9 May 2018

Our Reference: SYD17/01417/02 (A21587996)
Department Ref: SSD 8816

**ENVIRONMENTAL IMPACT ASSESSMENT – HEALTH SERVICES ADMINISTRATION
BUILDING - ROYAL NORTH SHORE HOSPITAL, ST LEONARDS**

AREA PLANS - LEVELS B2 -
05 - STATUTORY GFA

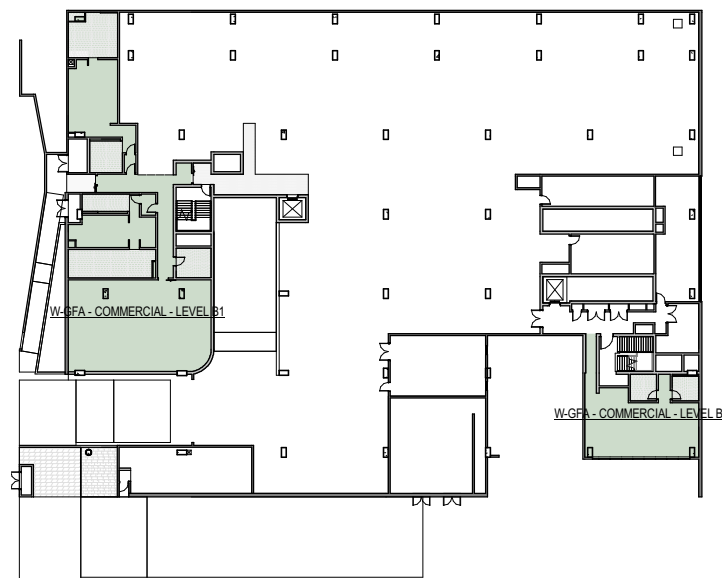
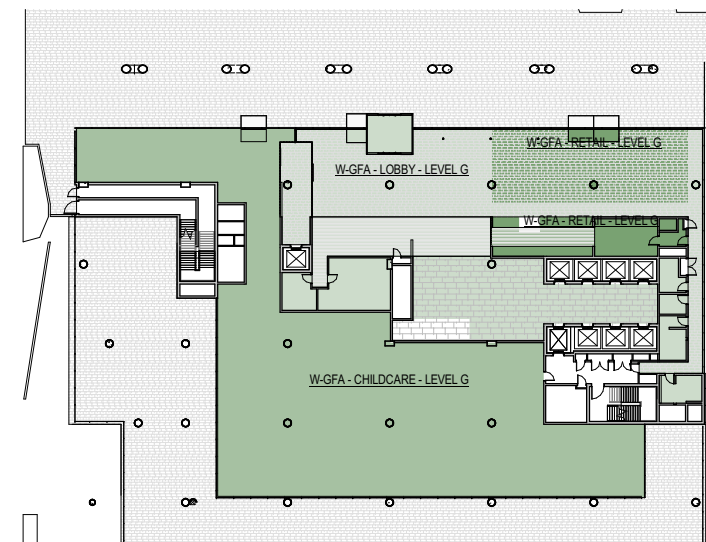
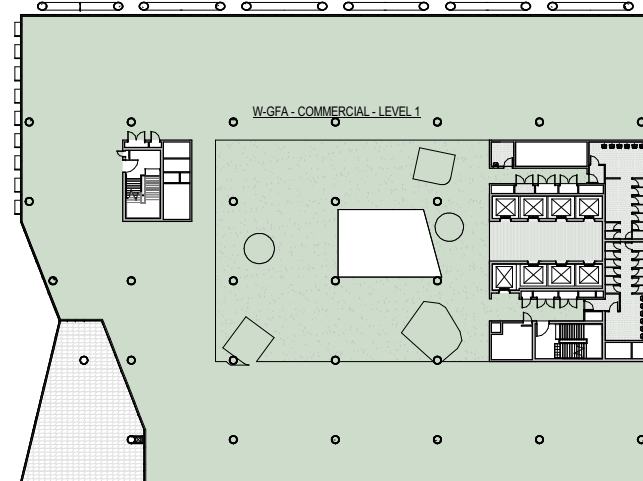
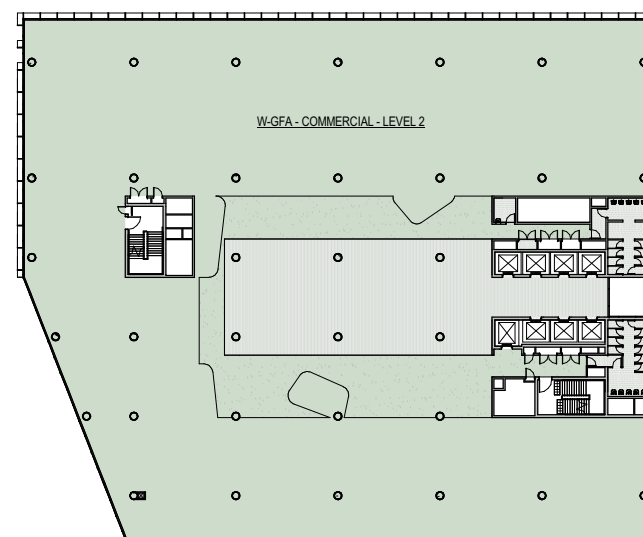
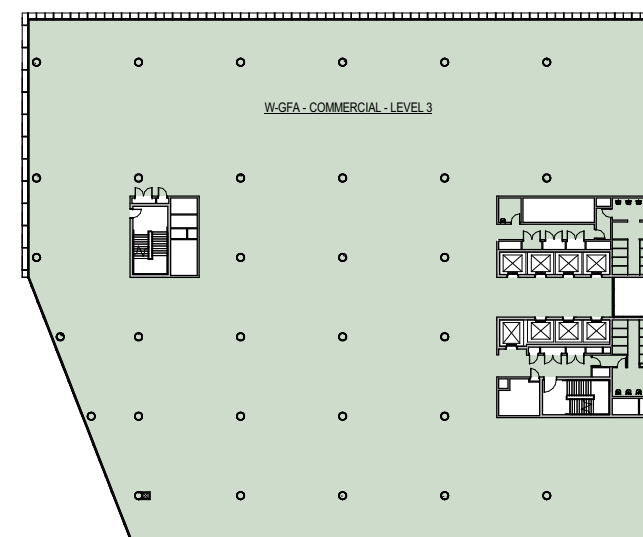
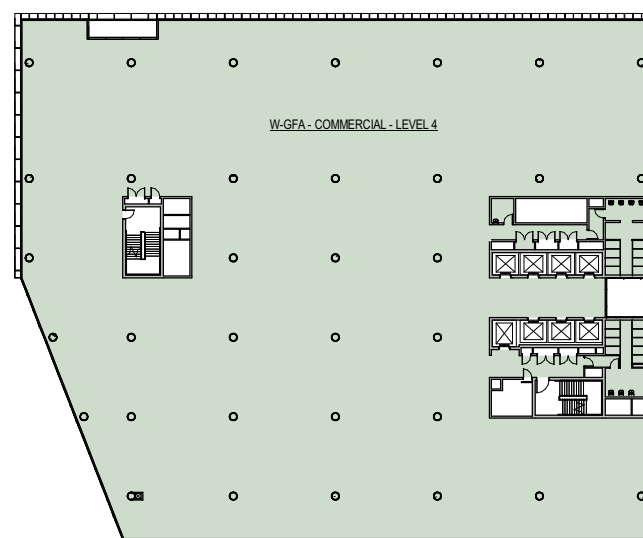
1. Roads and Maritime notes that the trip generation should be calculated as per the GFA (Gross Floor Area) of the development site, not the reduced parking (267 as opposed to 96 parking spaces used for trip generation calculation in the report provided). It is understood that there would be a considerable volume of drop off & pick up trips related with the development.
